Application by Orsted Hornsea Project Three (UK) Ltd for an Order granting Development Consent for the proposed Hornsea Project Three Offshore Wind Farm

The Examining Authority's Written Questions and Requests for Information

Issued on 9 October 2018

Figure 3.21 Construction Compound Options.

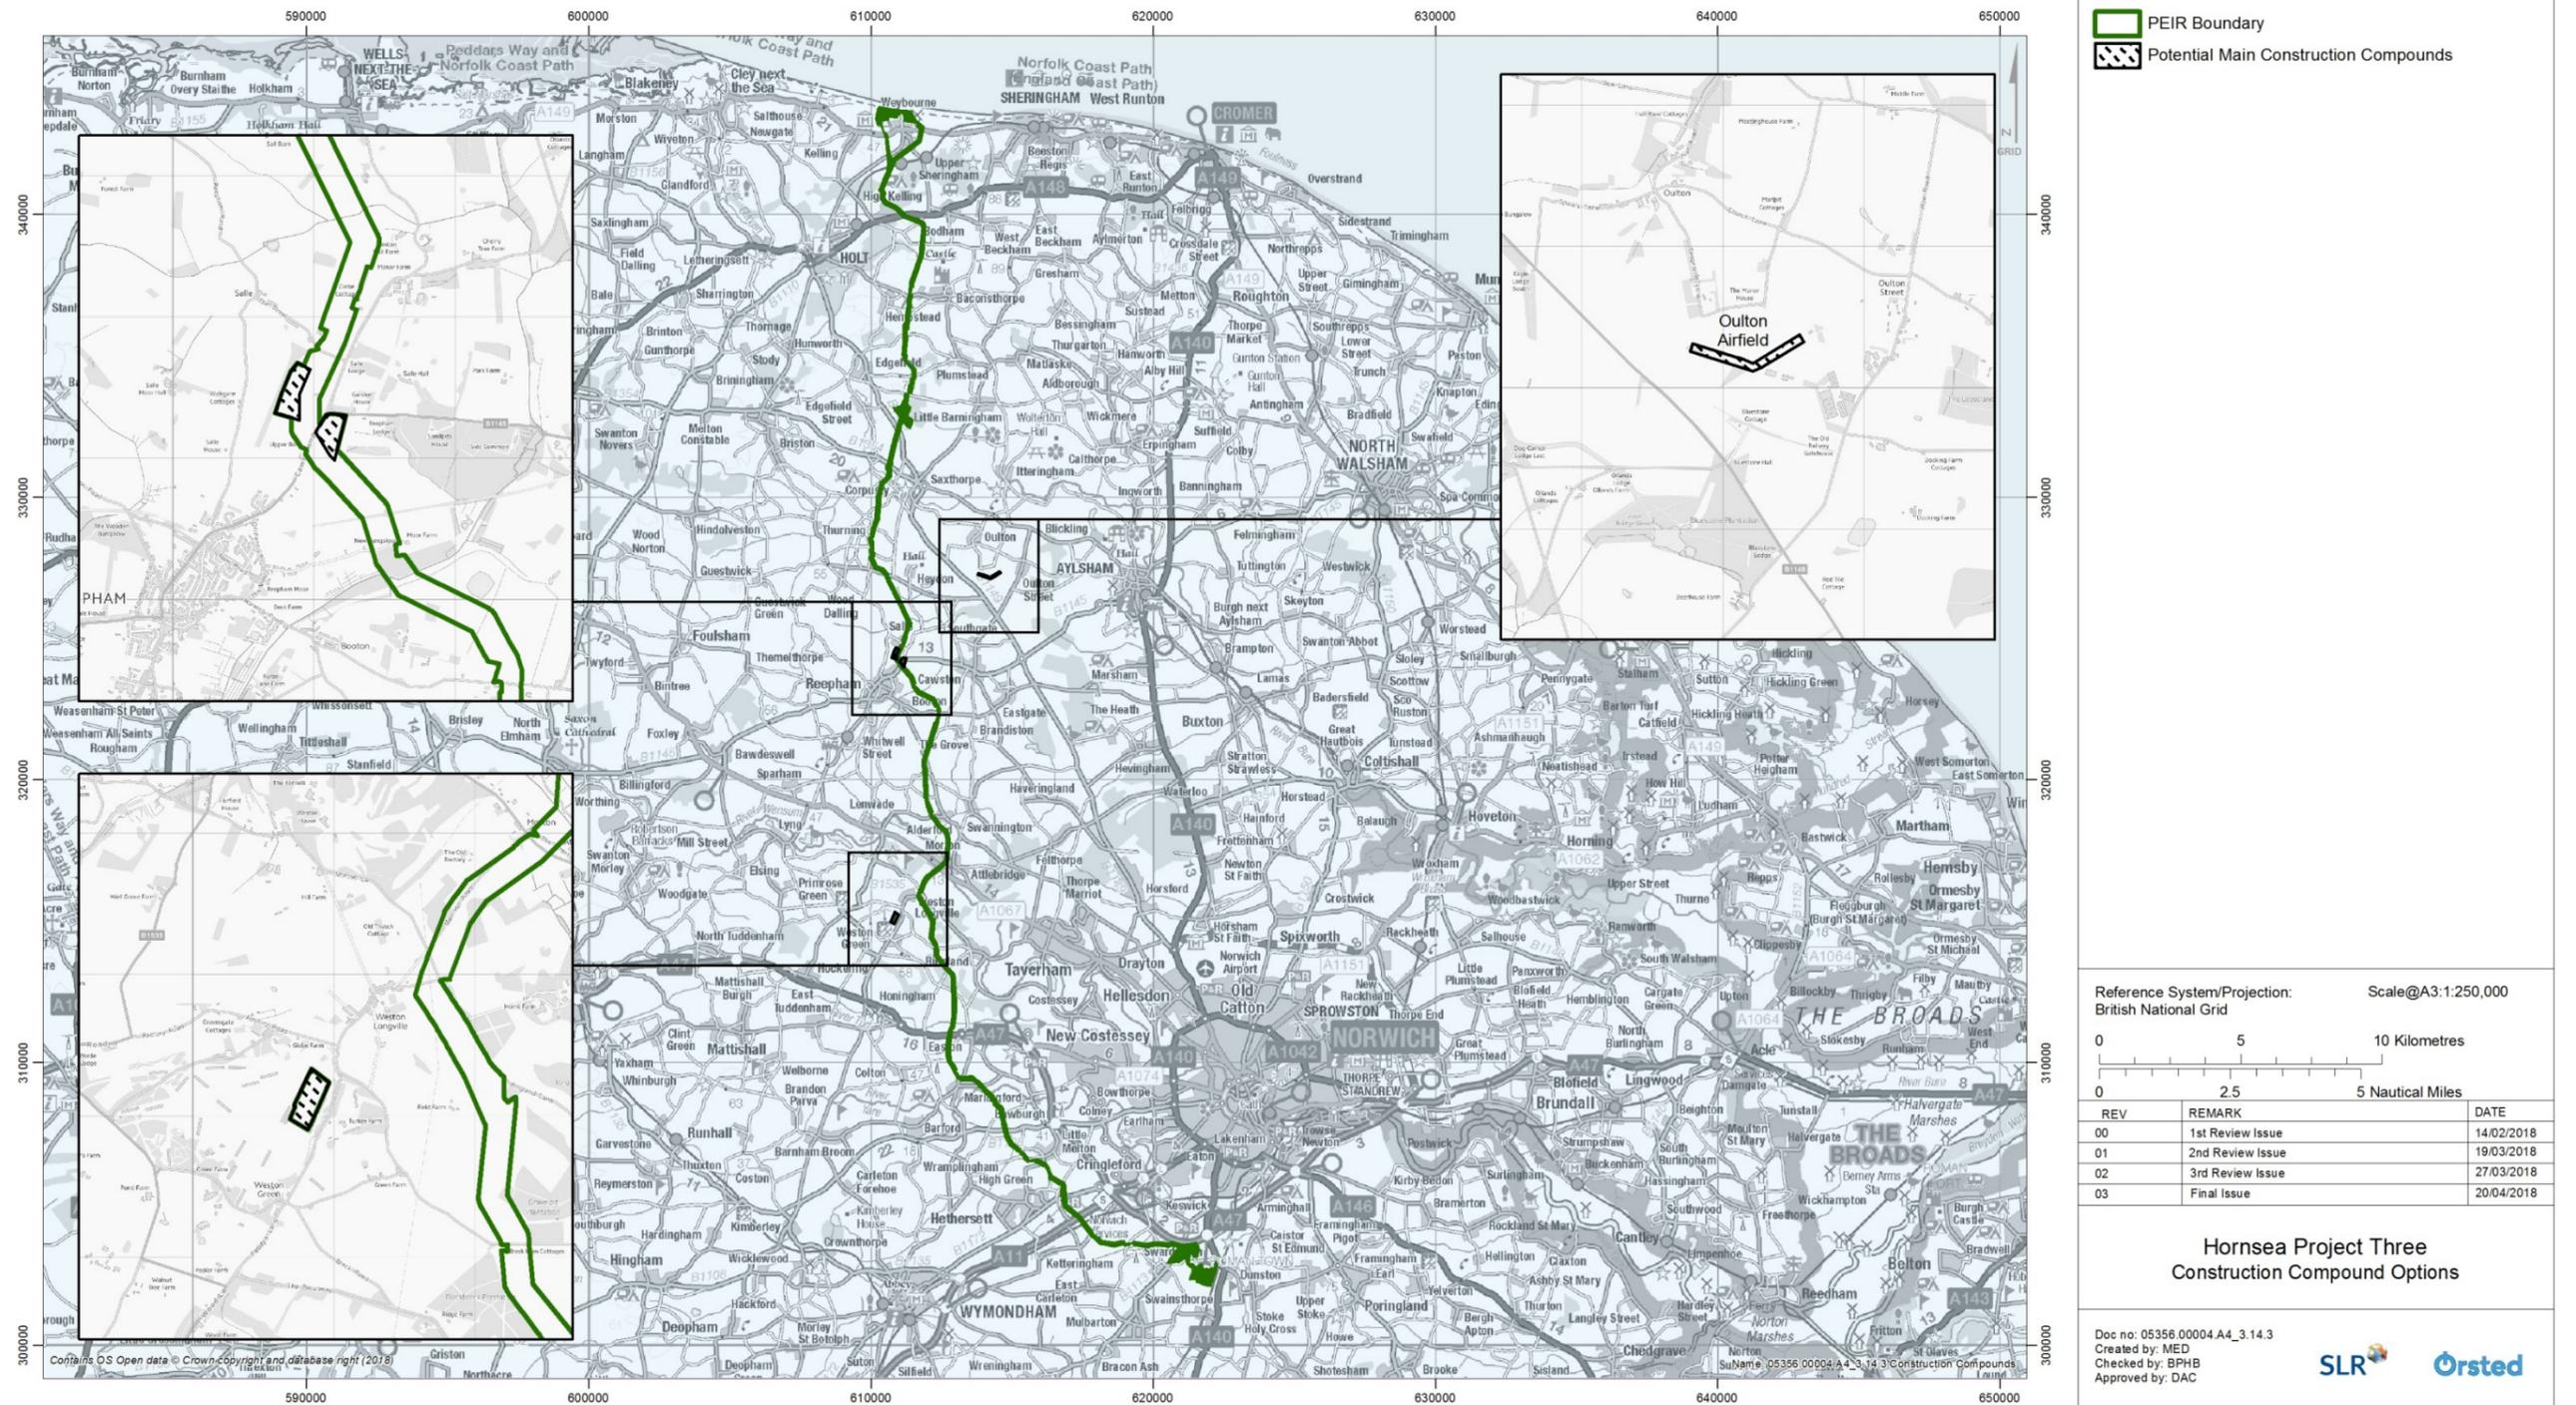
What were the reasons for offering a connection to another developer rather than Hornsea Project Three?
Q1.1.13	Applicant	<p>Figure 3.21 of Annex 4.3 to the ES [APP-094] indicates the construction compound options that were considered.</p> <p>Please provide further justification for the selection of Oulton Street as the proposed location for the main construction compound.</p>
Q1.1.14	Applicant	<p>Mulbarton Parish Council [RR-049] suggests that the Lafarge Aggregates quarry at Mangreen should have been considered as an option for the onshore HVDC converter/HVAC substation.</p> <p>To what extent was the quarry site considered and, if it was considered, what were the reasons for rejecting it?</p>
Q1.1.15	Applicant	<p>Figure 3.8 of the ES [APP-094] shows the shortlisted options for locating the onshore HVDC converter/HVAC substation. The rejected option (Option A) is described as physically more constrained than the selected option.</p> <p>What are the relative advantages and disadvantages of the two shortlisted options in terms of landscape and visual impacts and other environmental impacts?</p> <p>Please provide further justification for the selection of Option B.</p>
